**Our Case Number:** ABP-314232-22

**Re:** DART+ West Railway Order - Dublin City to Maynooth and M3 Parkway  
County Dublin, County Meath, County Kildare

Ref: 314232 / Confey Train Station

Drawing Title: STRUCTURE DESIGN OBG14 BRIDGE WIDENING OBG14 ROAD BRIDGE, FINAL STATE

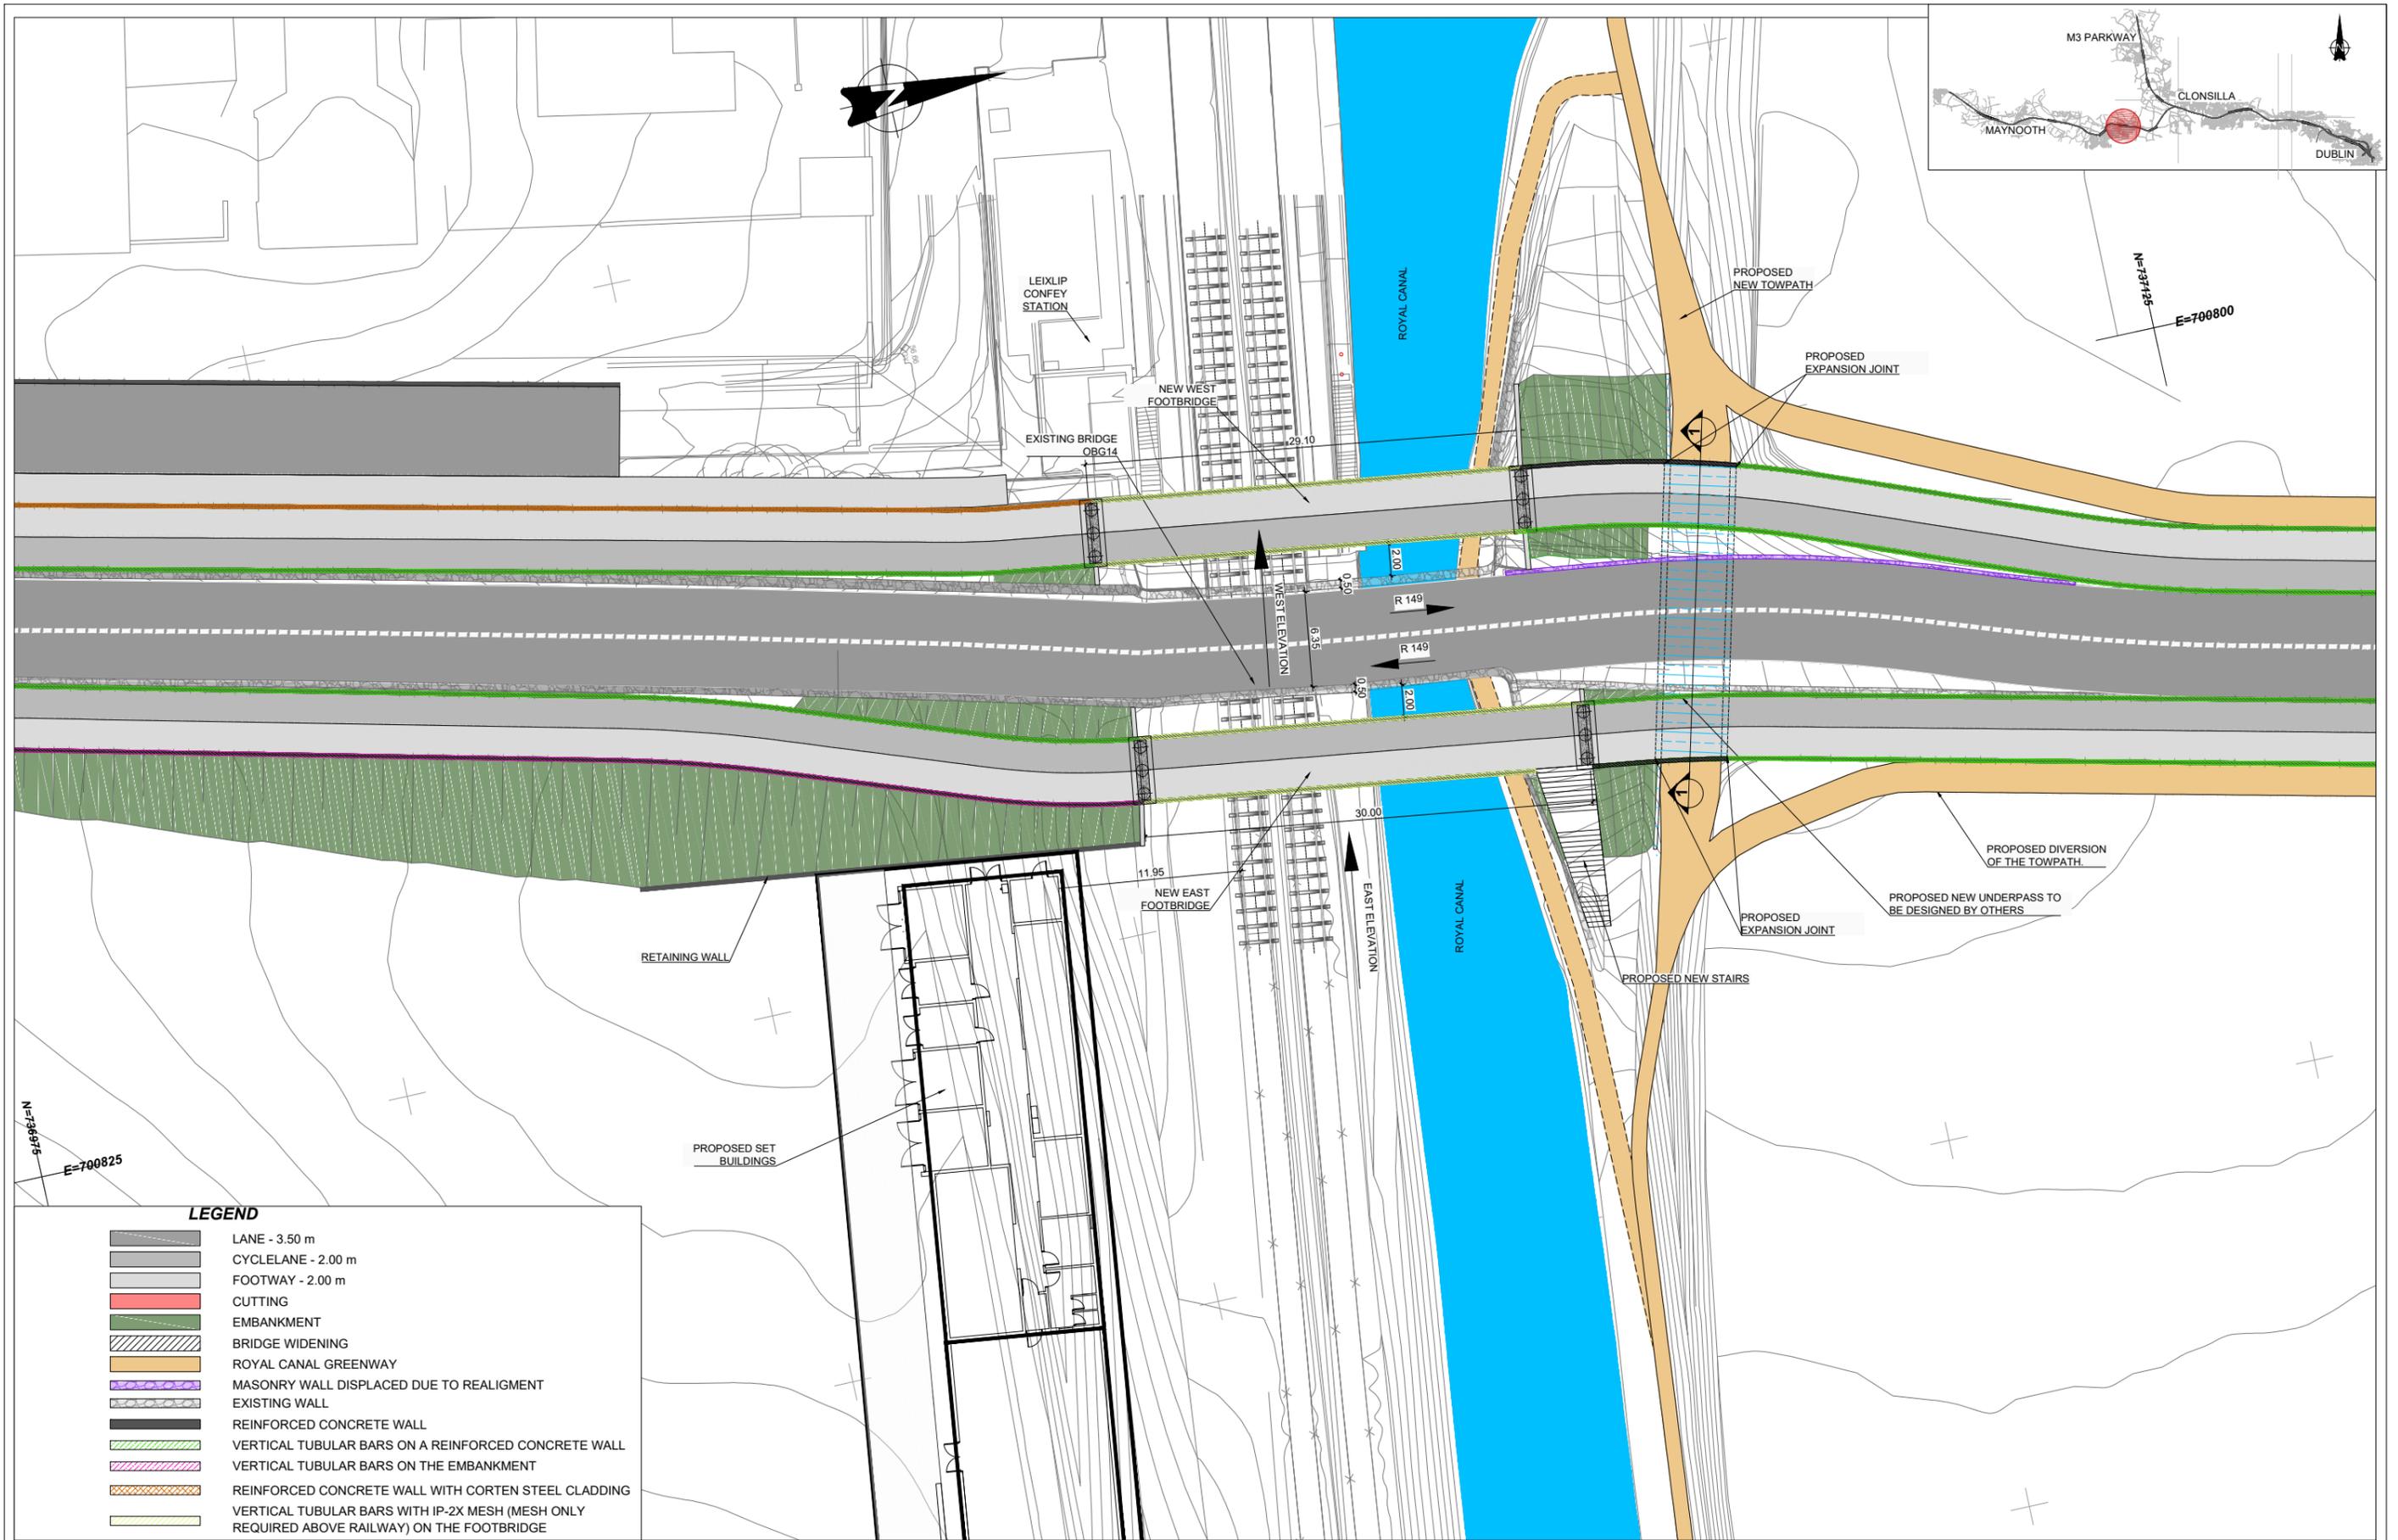
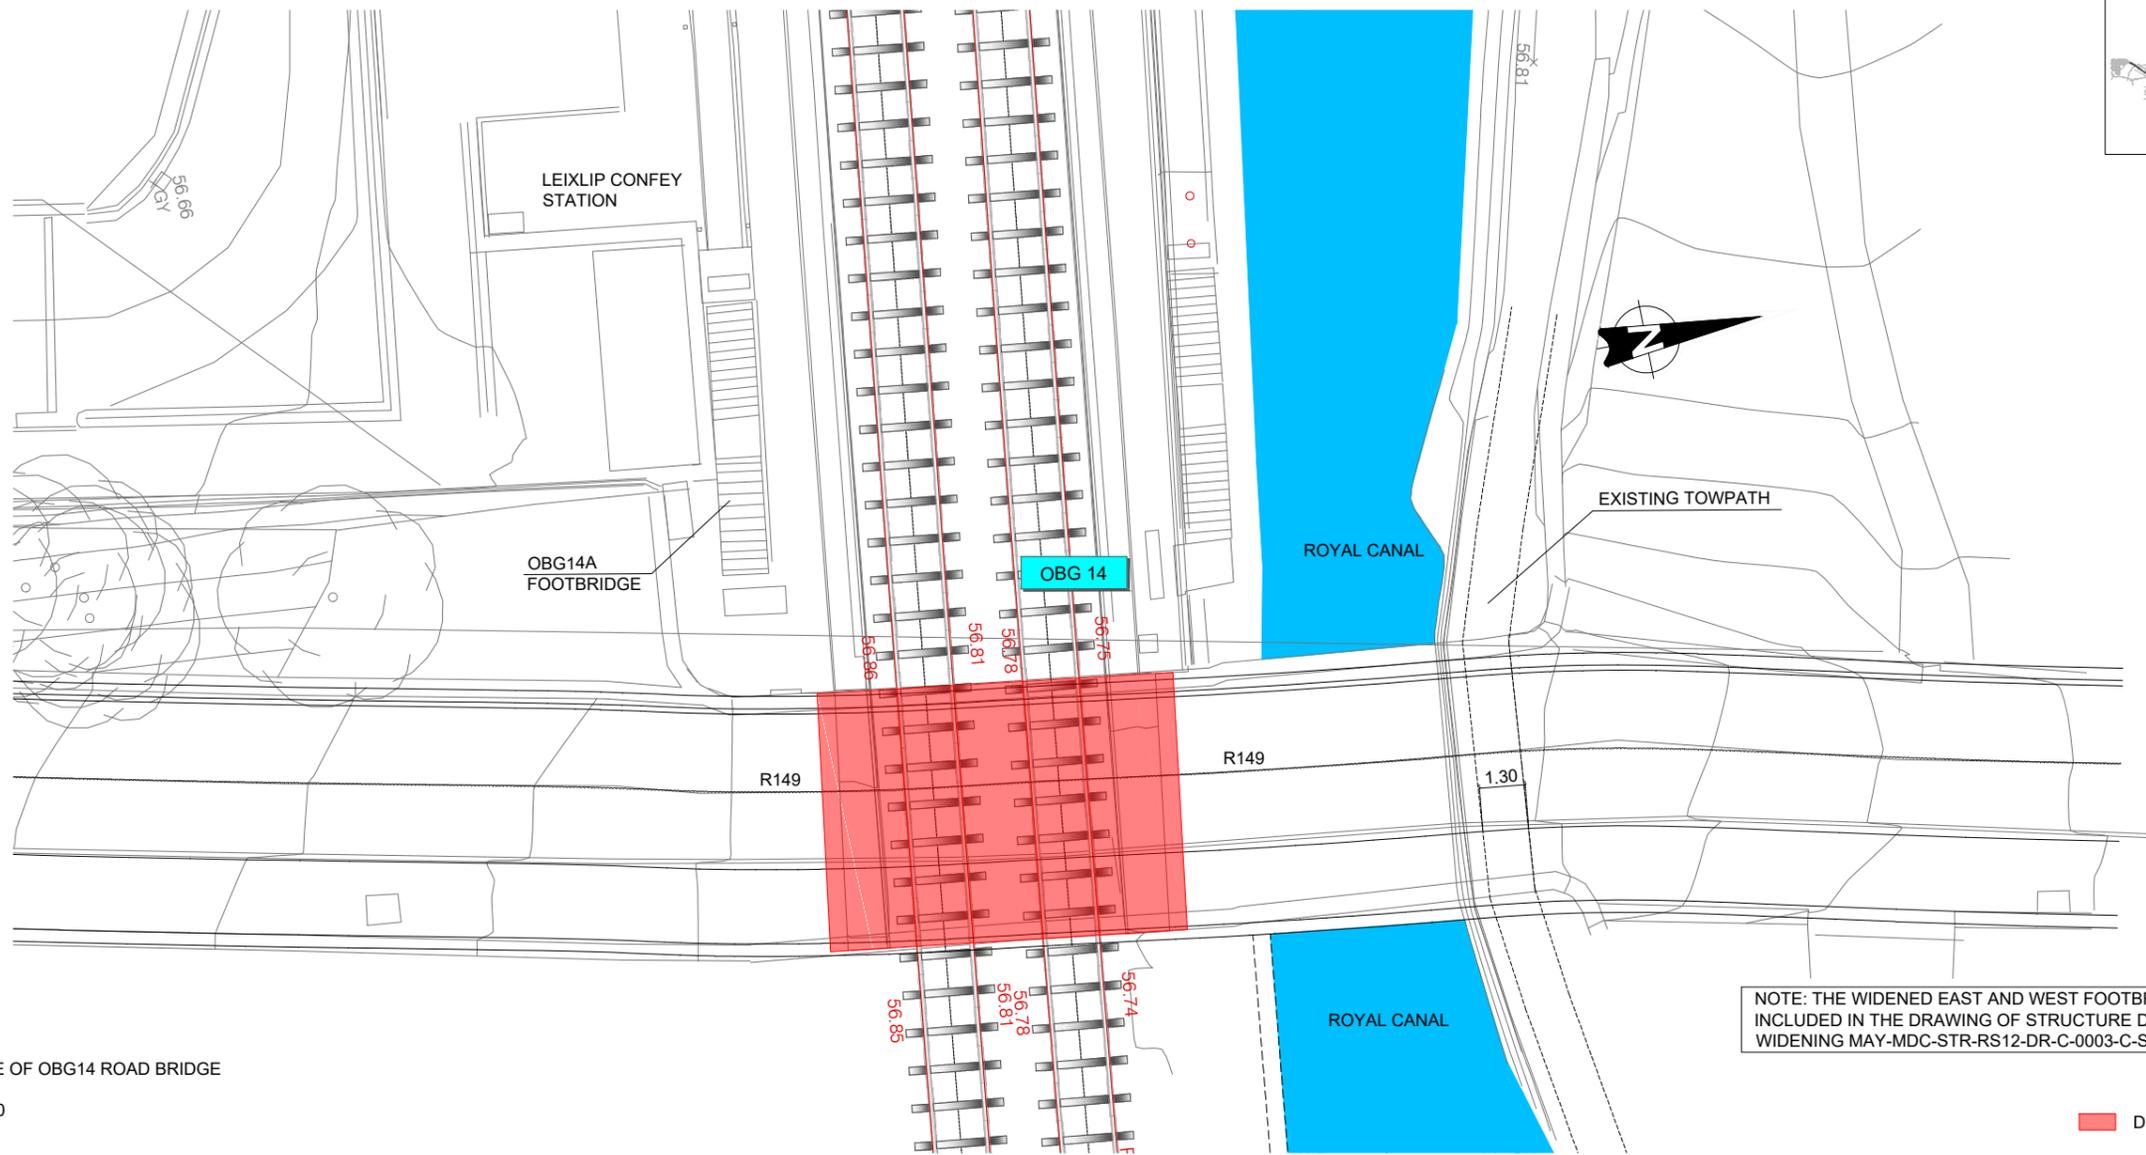
With regard to the environmental impact that this project will have on the locality we wish to bring to your attention that at a time when there is real concern for climate change etc. why would any Government consider felling a row of mature oak trees to make way for a second walkway that is not needed, one walkway of the width proposed is and will be more than adequate.

DNO LEIXLIP CONFEIY
(Notification Number: 5000450441)

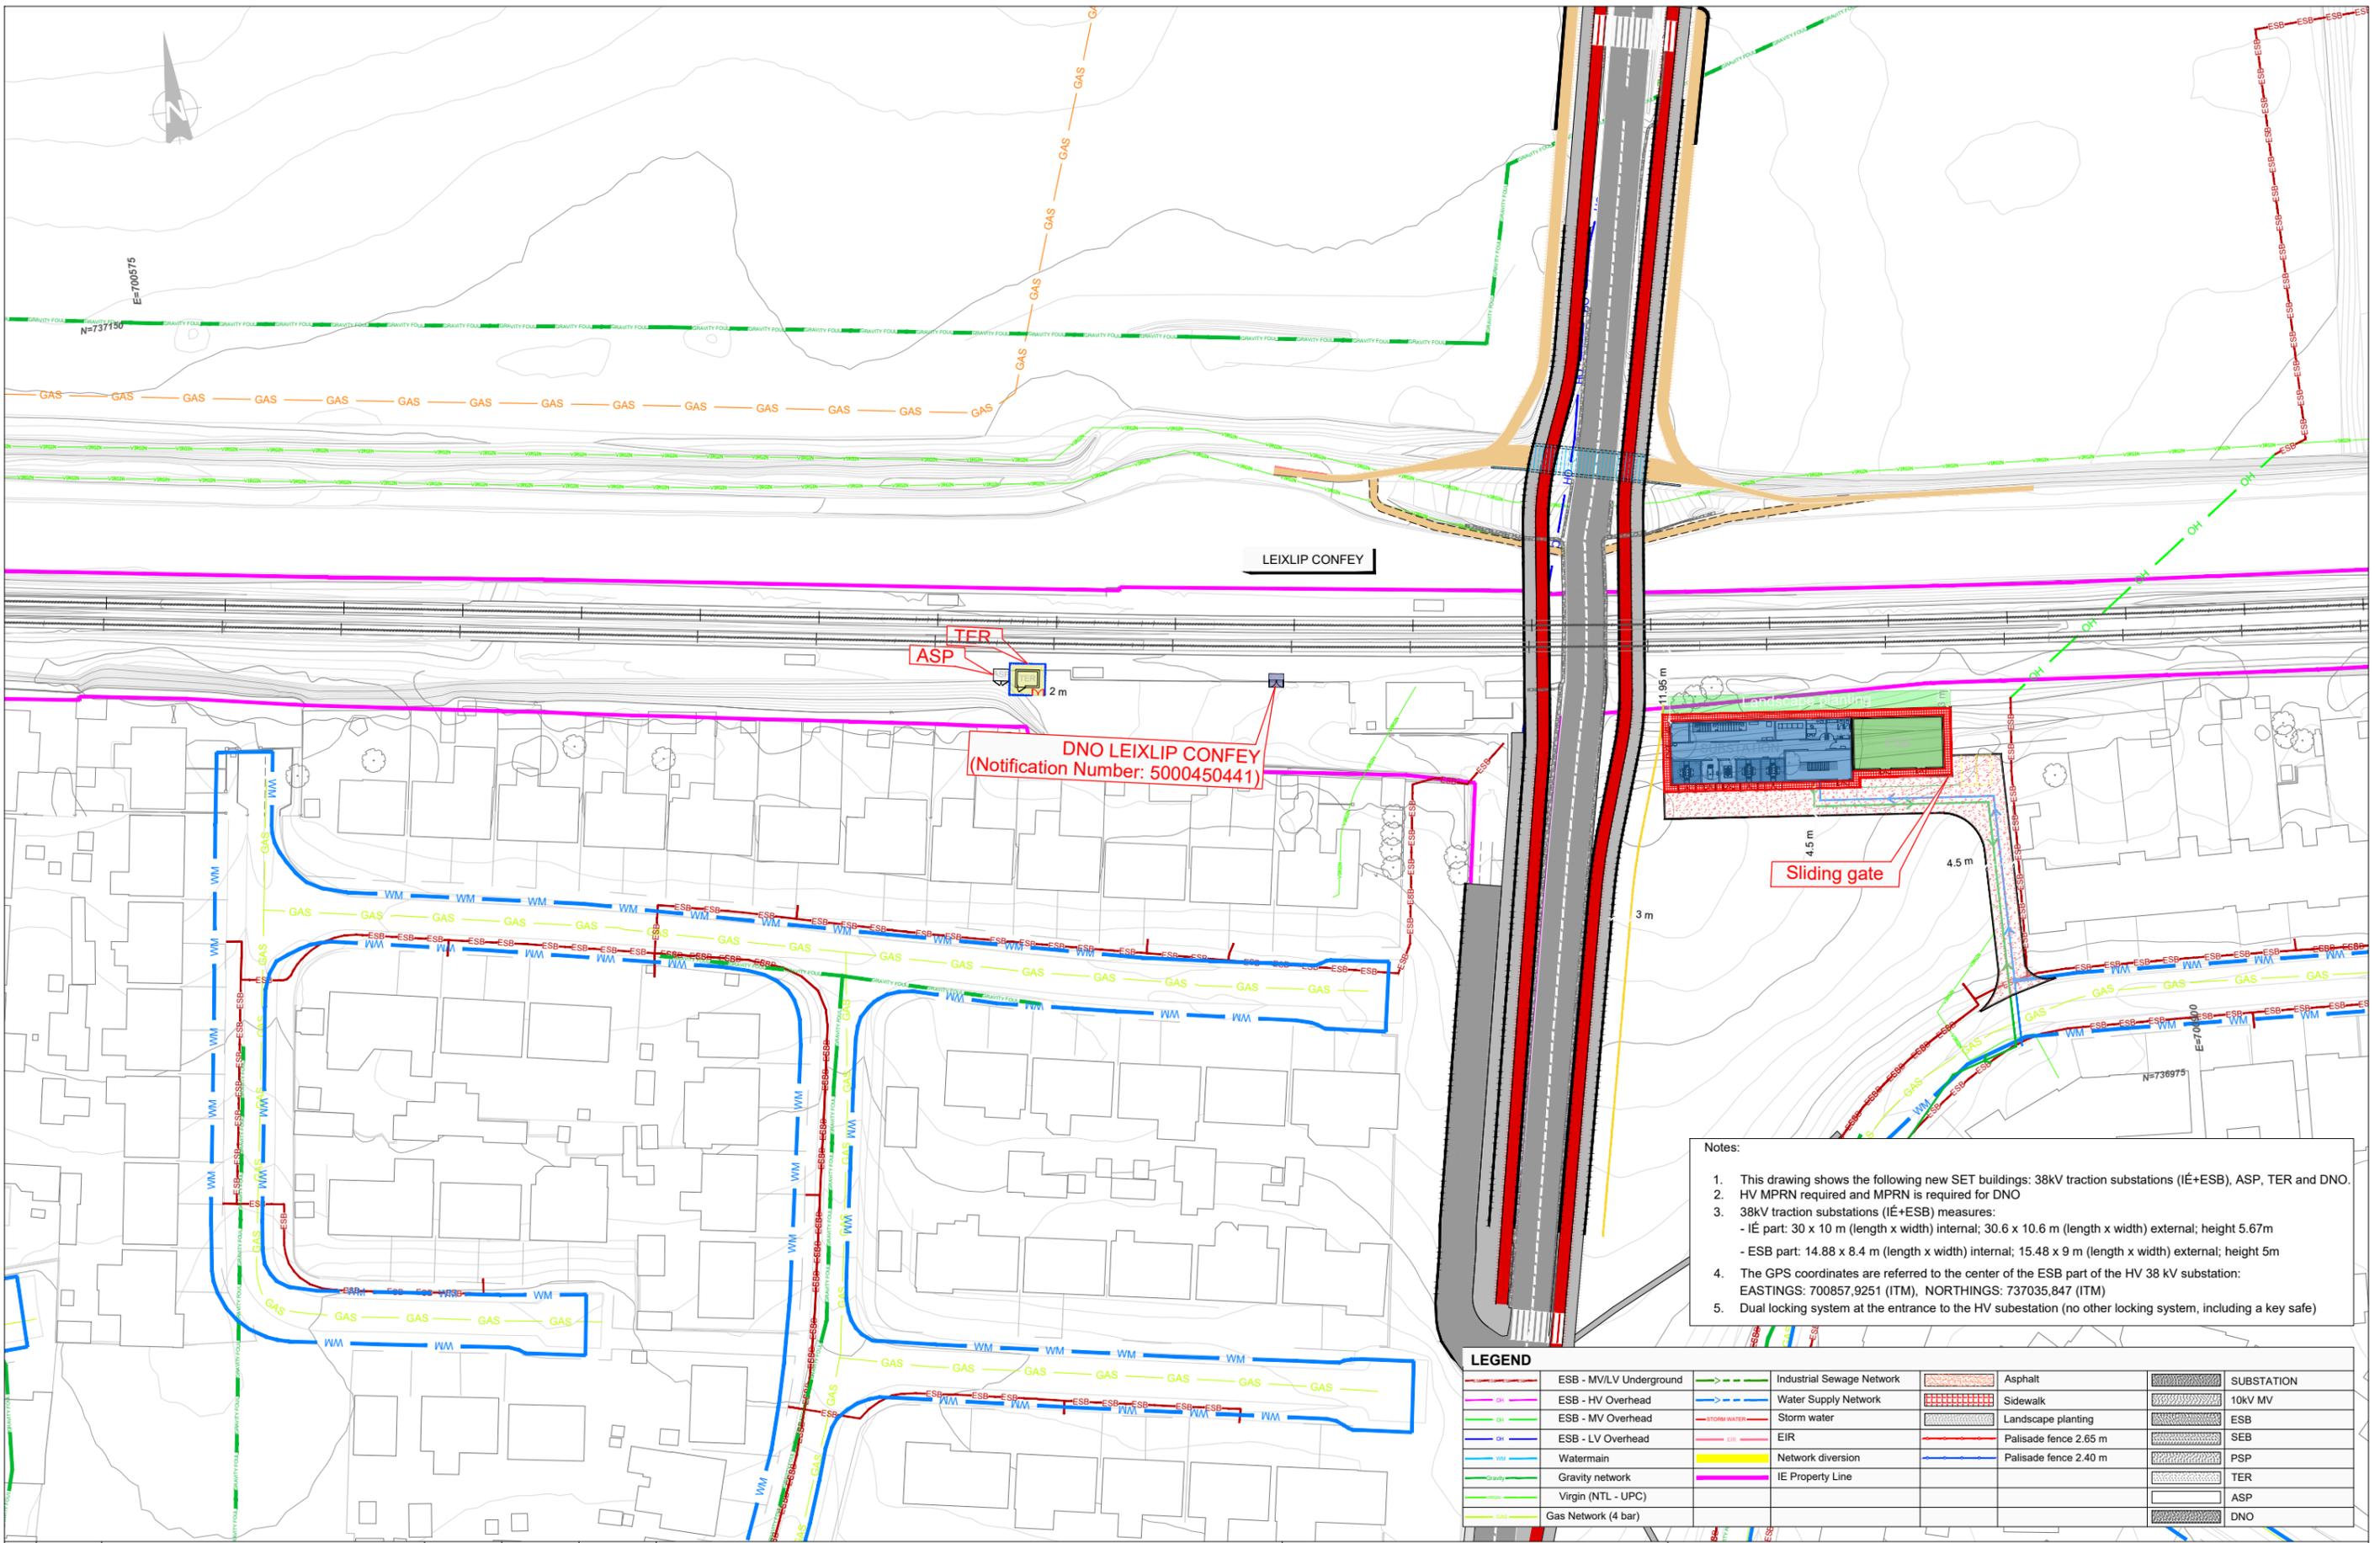
Also why would they consider destroying a green area with a massive substation, access roadway to it, and also putting a construction compound on the same green area in a residential area, when there is more than adequate space both at Confey Station and over Cope Bridge opposite the GAA playing fields.
